City of Portland, Maine - Building or Use Permit Application
 389 Congress Street, 04101 Tel: (207) 874-8703, Fax: (207) 874-8716

Permit No: 09-1190	Issue Date:	CBL: 344 E036001
------------------------------	--------------------	----------------------------

Past Use: Commercial / Walgreens	Proposed Use: Walgreens / one free standing sign (one panel 7'1 1/2" x 8'4 1/2" & second panel - LED- 3'8 x10'11") - two wall signs (each has Walgreens script, photo & pharmacy)	Permit Fee: \$747.50	Cost of Work: \$0.00	CEO District: 5
Proposed Project Description: one free standing sign (one panel 7'1 1/2" x 8'4 1/2" & second panel - LED- 3'8 x10'11") - two wall signs (each has Walgreens script, photo & pharmacy)		FIRE DEPT: <input type="checkbox"/> Approved <input type="checkbox"/> Denied	INSPECTION: Use Group: Type	
		Signature:	Signature:	
PEDESTRIAN ACTIVITIES DISTRICT (P.A.D.)				
Action <input type="checkbox"/> Approved <input type="checkbox"/> Approved w/Condition <input type="checkbox"/> Denied				
		Signature:	Date:

Pharmacy
Photo
Exit
Elevation #2 - So
Walgreens script
Pharmacy
Photo
Elevation #3 - So
NA
Elevation #4 - Nc
Drive Thru Pharm
Clearance
Elevation #5 - To
Window Graphic
Total for Wall sig
Ground Signs
Pylon w/ LED Re:
Primary Panel
LED Readerboard
Total for ground
TOTAL

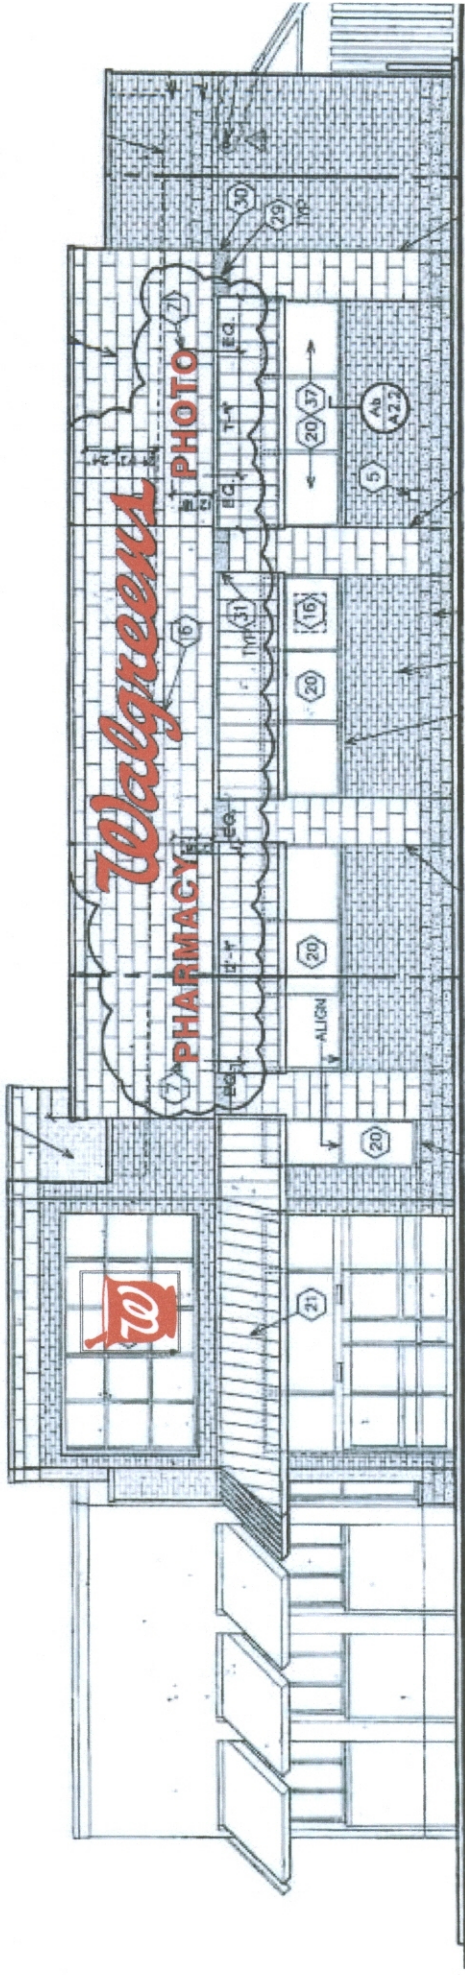
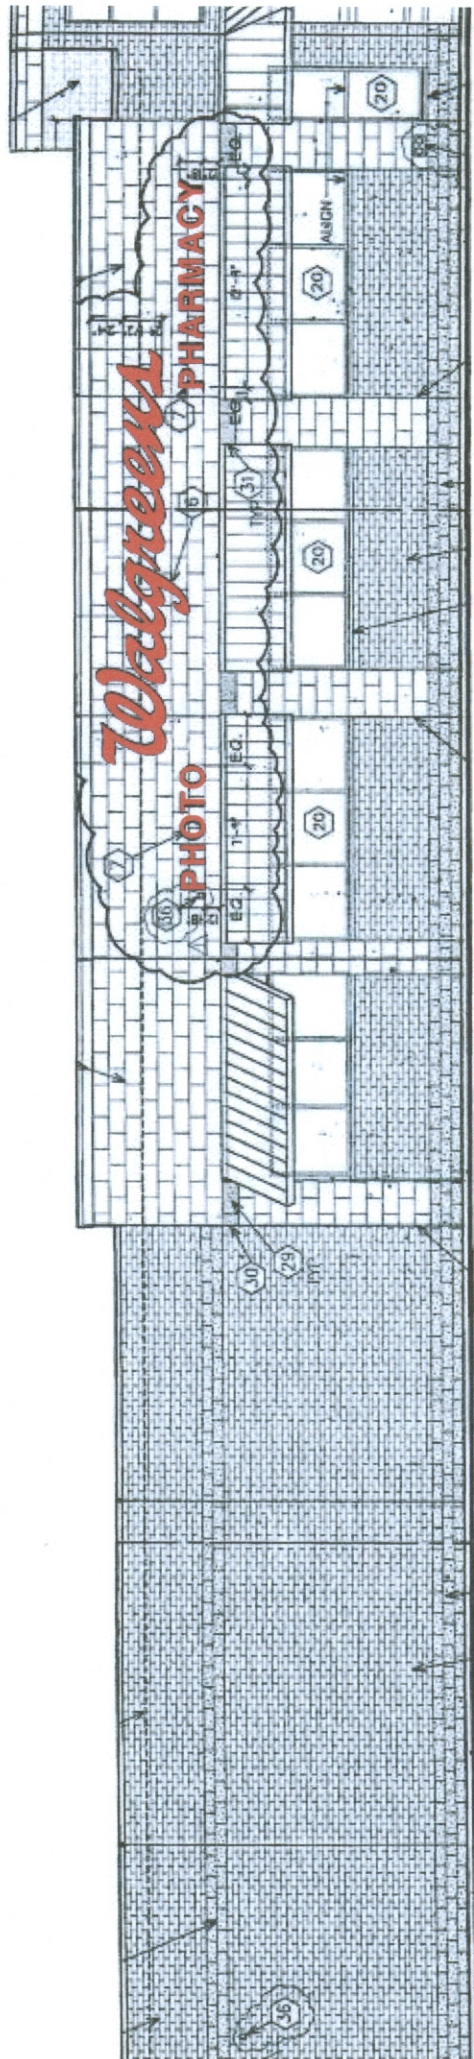
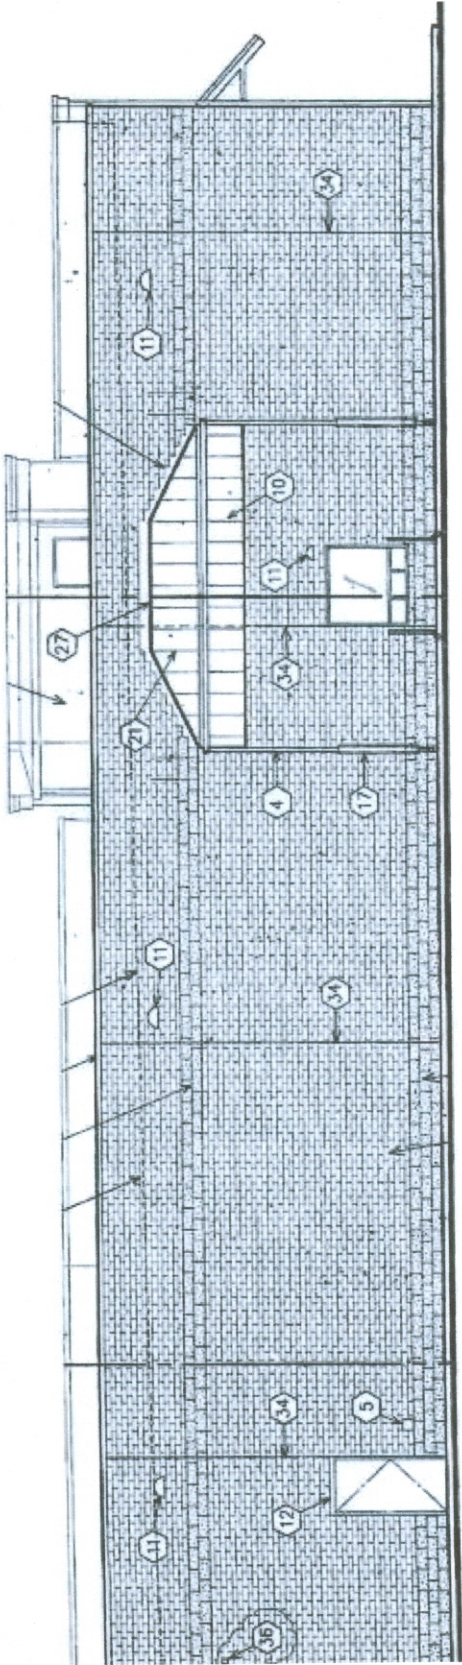
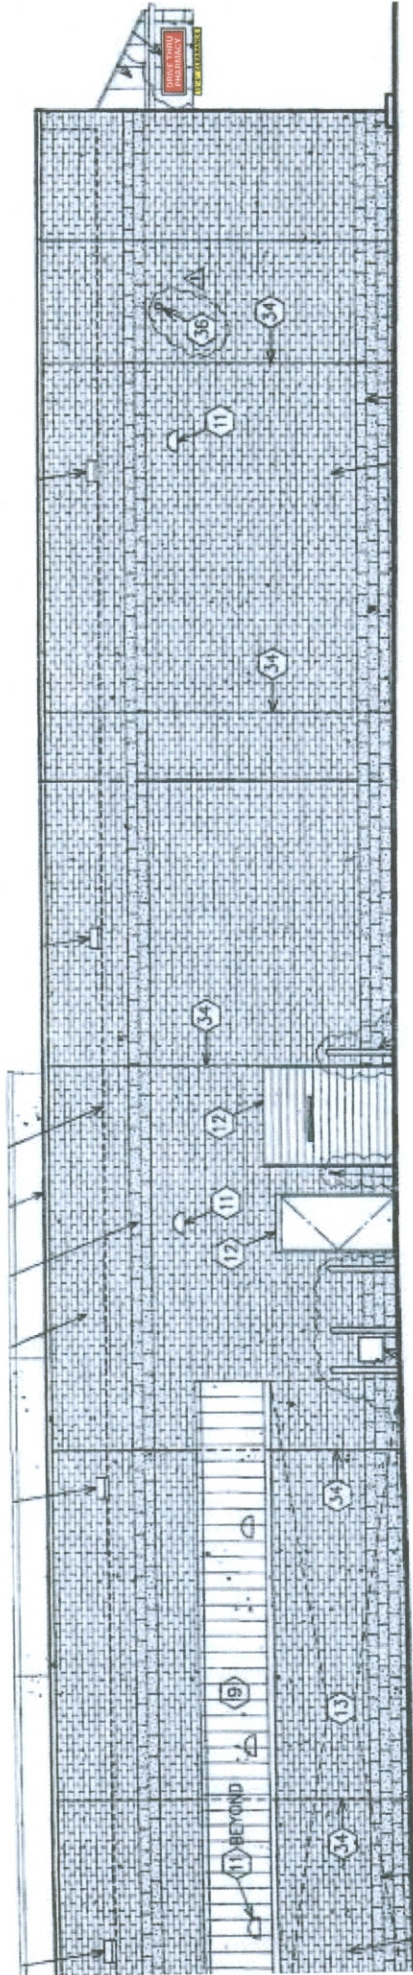
Comments:
10/29/2009-amachado: Wall signs are over the maximum allowable square footage total of 150 sf. Giving permit to planning under section 14-368.5(g).

1) Approved for special exception under site plan ordinance.
